Application by NNB Generation Company (SZC)
Limited for an Order Granting Development
Consent for The Sizewell C Project

Planning Inspectorate Ref: EN010012

Summary of Oral Representation at Issue
Specific Hearing 7 on Biodiversity and Ecology

Submitted for Deadline 5 (23 July 2021)

DRAWING TITLE:
 FIGURE 1.1
 WESTLETON MARSH HARRIER COMPENSATORY HABITAT LOCATION

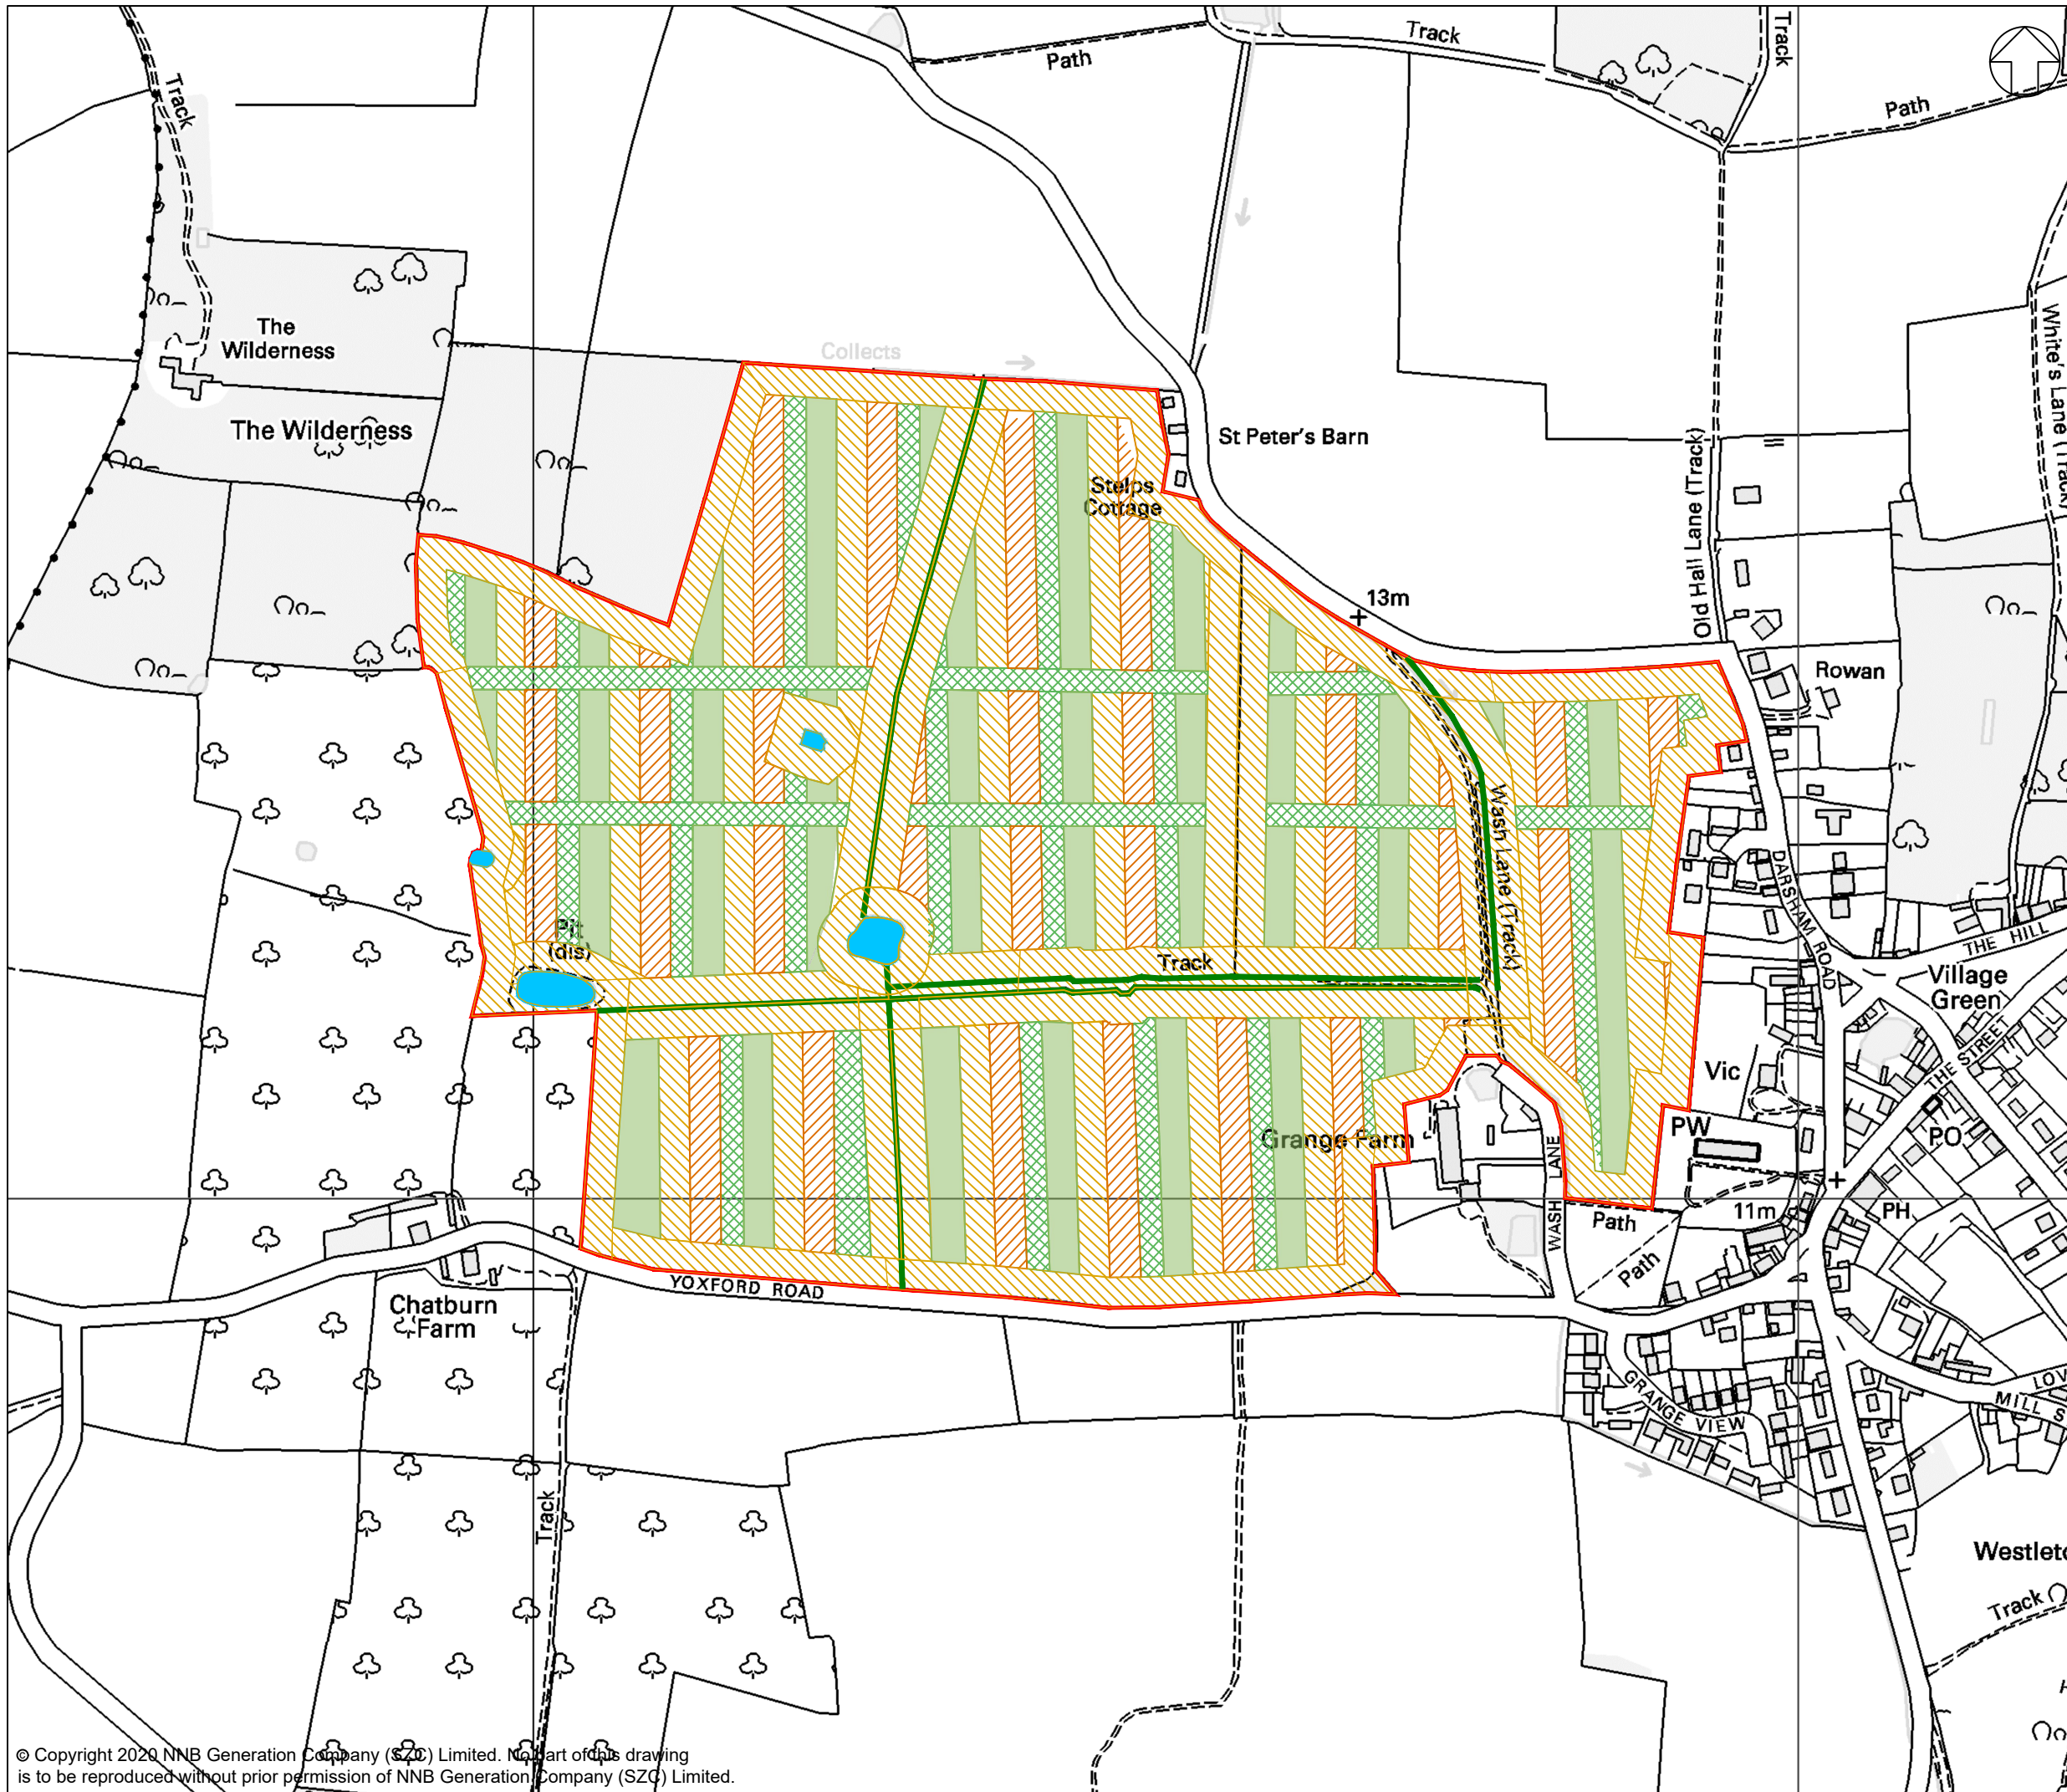
6. The focus of the oral representation was on how the parcel of land at Westleton (described in the Applicant's document REP3-053: *9.35 Marsh Harrier Compensatory Habitat Report*) has come to be proposed for inclusion in the DCO application as marsh harrier compensatory habitat.

- B. Dr Buisson assessed that area of land at Westleton based on the criteria stated in the Applicant's submission that gave background to the requirements for compensatory habitat (APP-259: *Marsh Harrier Mitigation Area Feasibility Report*) and his knowledge of the foraging ecology of marsh harrier. He found the Applicant's site selection process and choice of the land at Westleton deficient and faulted because:

- It does not include wetland. Since earlier at the ISH, the RSPB and the Applicant's lead ecology expert both stated that wetland is the ideal or optimal habitat for foraging marsh harrier, Dr Buisson did not dwell on that issue further.

- Part of the land adjoins the village of Westleton and the presence of people will cause disturbance, the presence of dogs will cause disturbance and the presence of cats will mean that there is a competitive predator for the small mammals and small birds that marsh harrier would be hunting. These factors make the land at Westleton less likely to be used by marsh harrier and to provide fewer feeding resources than a parcel of land located further from a village.
- The choice of this parcel of land fails to account for the distance from the breeding site to the compensatory habitat. Closer sites should be preferred in any selection process because it means that the foraging adults would expend less energy and less time flying back and forth from the nest site to the foraging area.

8. It was noted that after Dr Buisson spoke, through the procedural process of giving the Applicant "the last word", the Applicant's lead ecology expert stated that a site selection factor had been applied, which was that the selected compensatory habitat should be within 4 km of the breeding sites at Minsmere. This site selection factor was not included in the Applicant's submissions APP-259 and REP3-053. The Applicant's lead ecology expert stated that the land at Westleton was, at its closest, 3.5 km from the breeding sites at Minsmere. This is at the outer limit of the Applicant's own criteria and, given the time and energetic costs of flying back and forth to Westleton, strongly suggests that this parcel of land is not the best from the perspective of providing resources for breeding marsh harrier.
